From: [Pat Nicholson](#)
To: [Kelly Bacon \(CD\)](#)
Subject: RE: BL-19-00022 Horish - Notice of Application
Date: Monday, December 9, 2019 1:29:32 PM

From: Kelly Bacon (CD)
Sent: Monday, December 9, 2019 1:17 PM
To: Jesse Cox; Holly Erdman; Candie Leader; Pat Nicholson
Cc: Lindsey Ozbolt
Subject: BL-19-00022 Horish - Notice of Application

Please review the following Boundary Line Adjustment application submitted by Linda Horish (BL-19-00022). Any comments need to be submitted by 5pm on December 24, 2019. Please let me know if there are any questions.

Site Plan

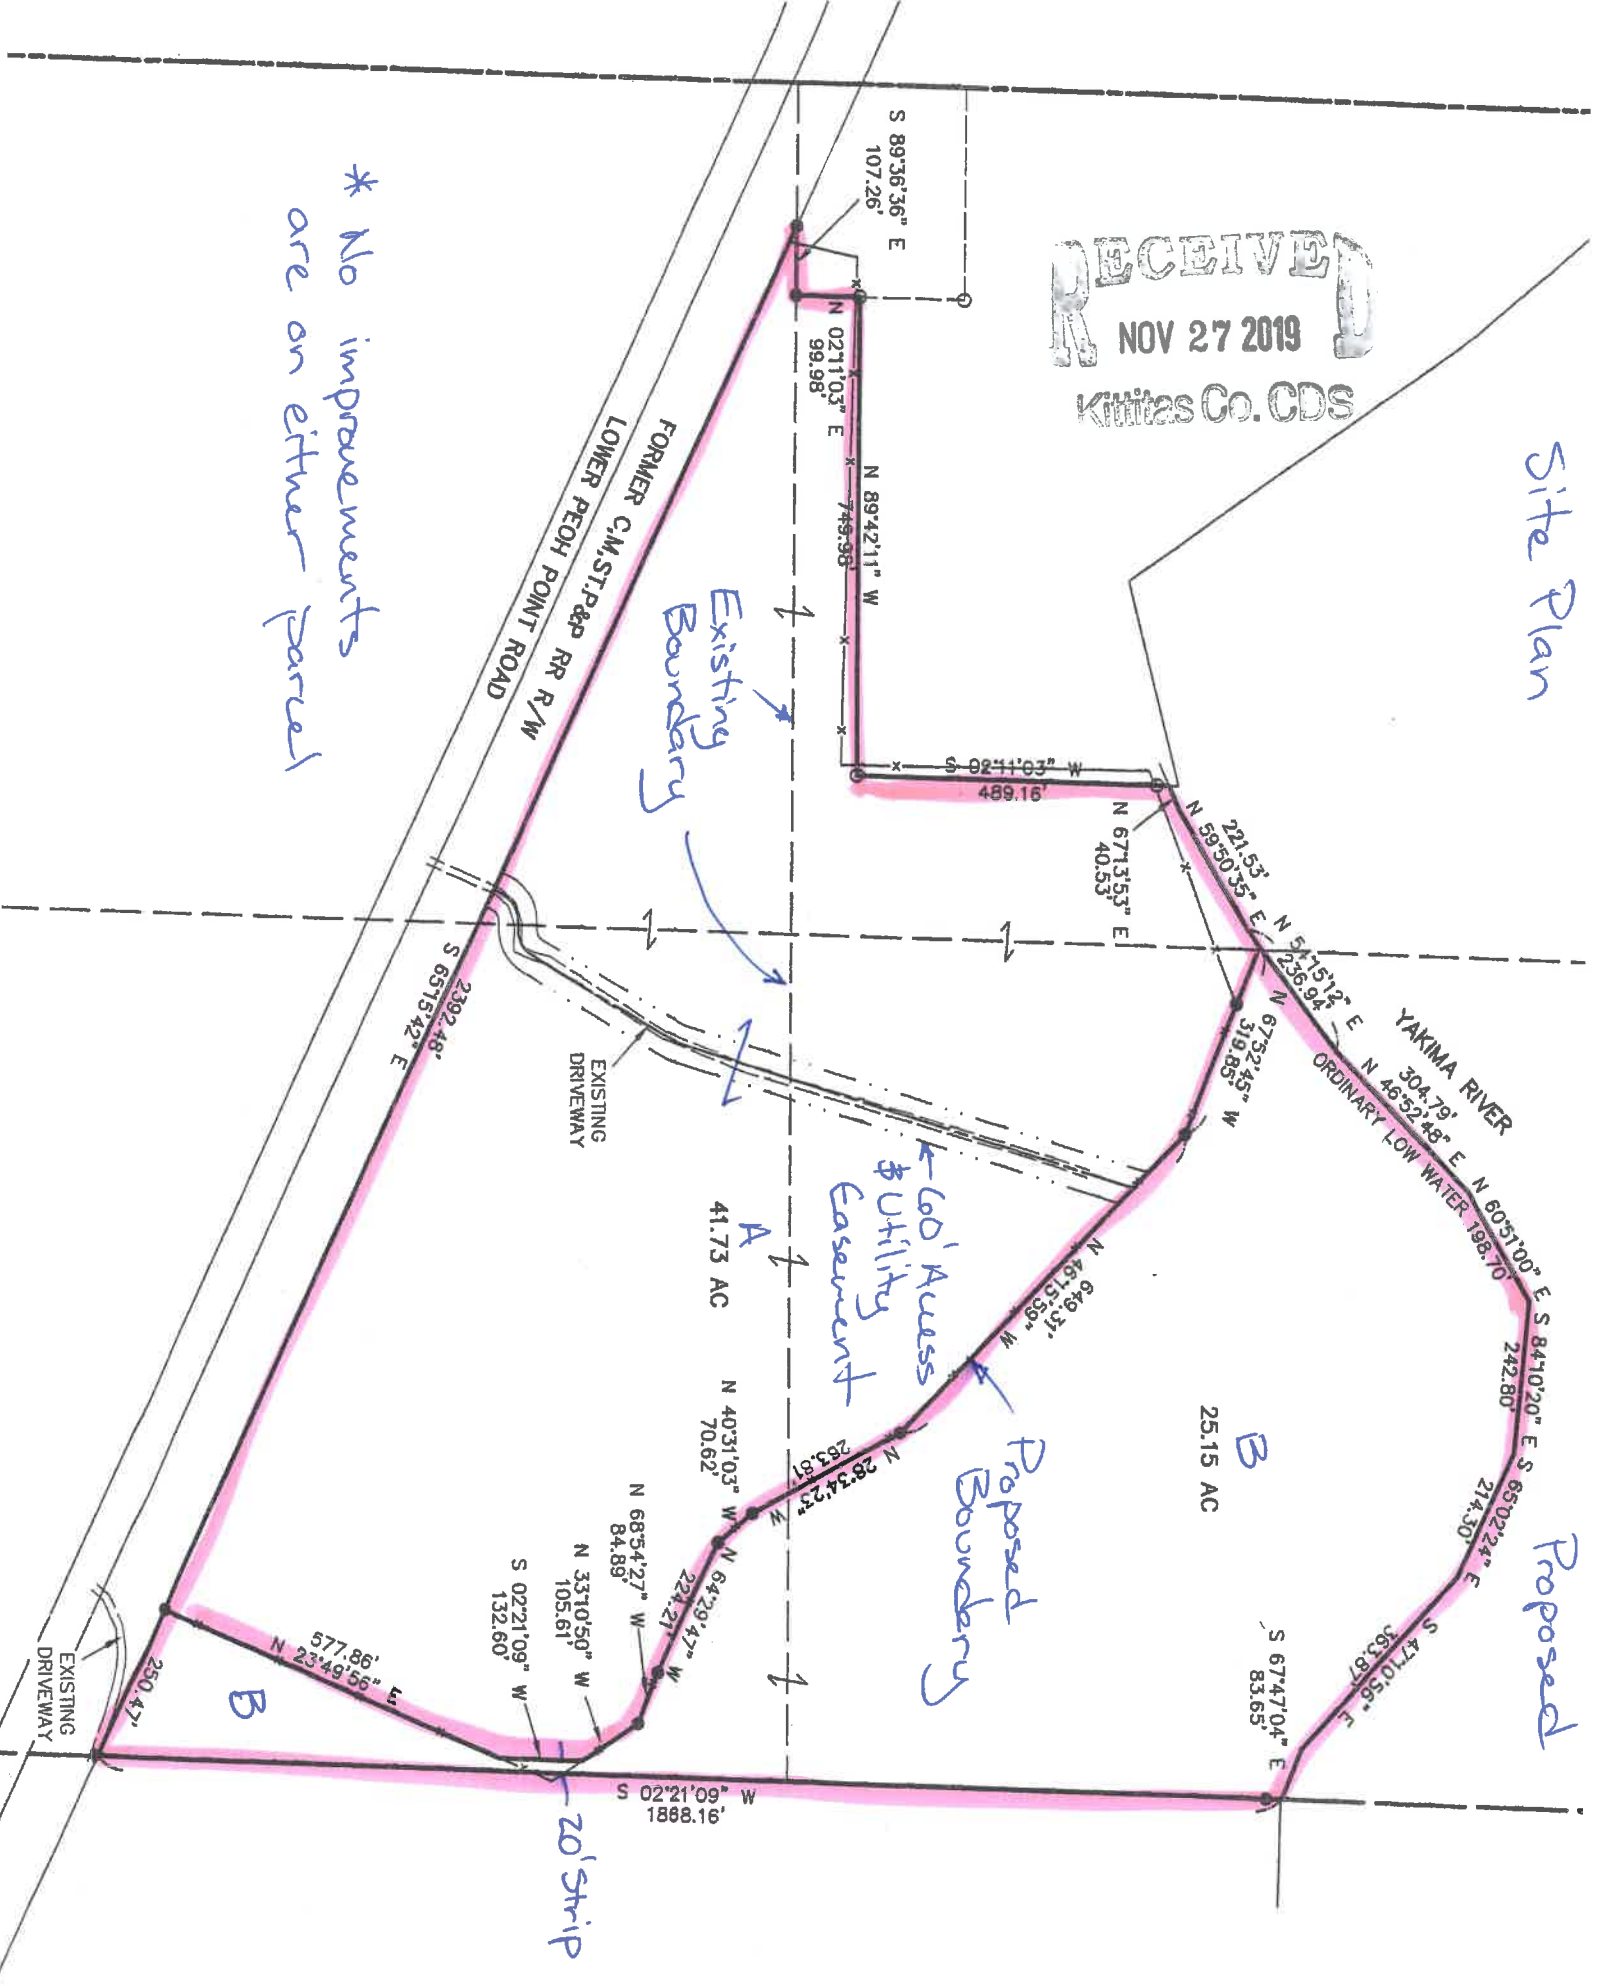
Existing access and driveway to Lower Peoh Pt. to meet current PW and IFC road standards.
